Application No: FG/51/20/HH
Site Address: 66 Elm Park Ferring BN12 5RW
Description of works: Ground floor porch extension, single storey rear extension, first floor front and rear dormer extension and conversion of garage to habitable use.

Thank you for your internet representation made on 19th May 2020 which has been recorded as an objection with the comments as follows:

Proposed West Elevation

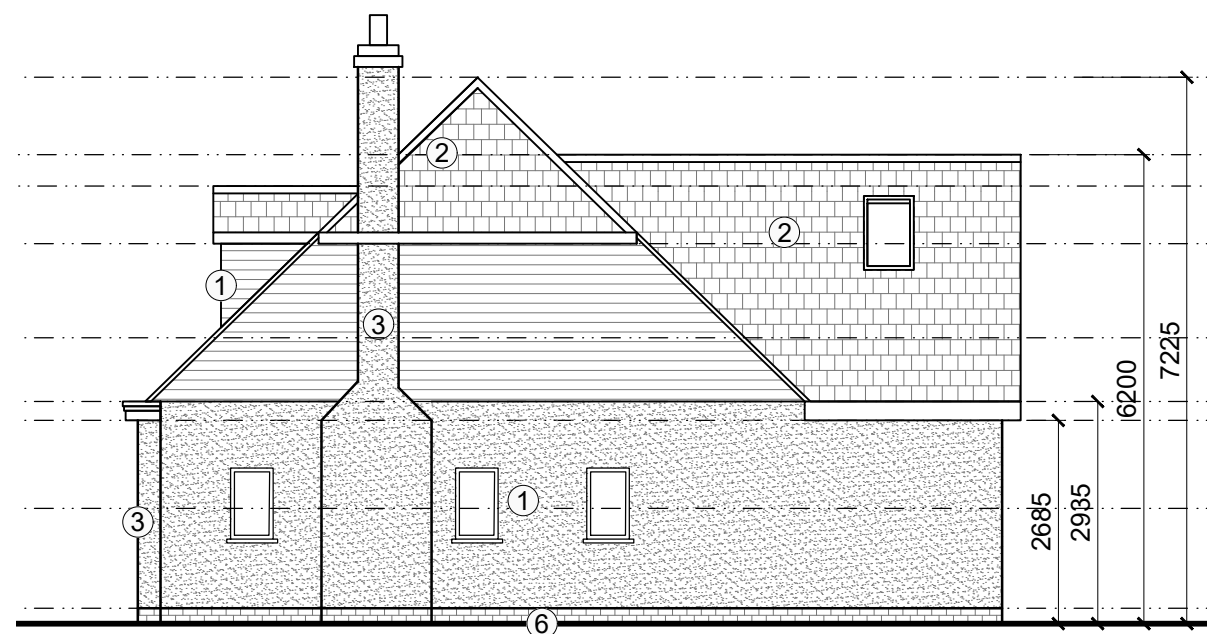
Ferring Parish Council requests that Planning Officers give particular consideration to the proposed roof window on the west elevation which would appear to overlook the neighbouring garden on the western side. Should site lines confirm this and should officers be minded to approve the application, we would ask that it is done so with a condition that the window is of obscure glass and fixed closed.
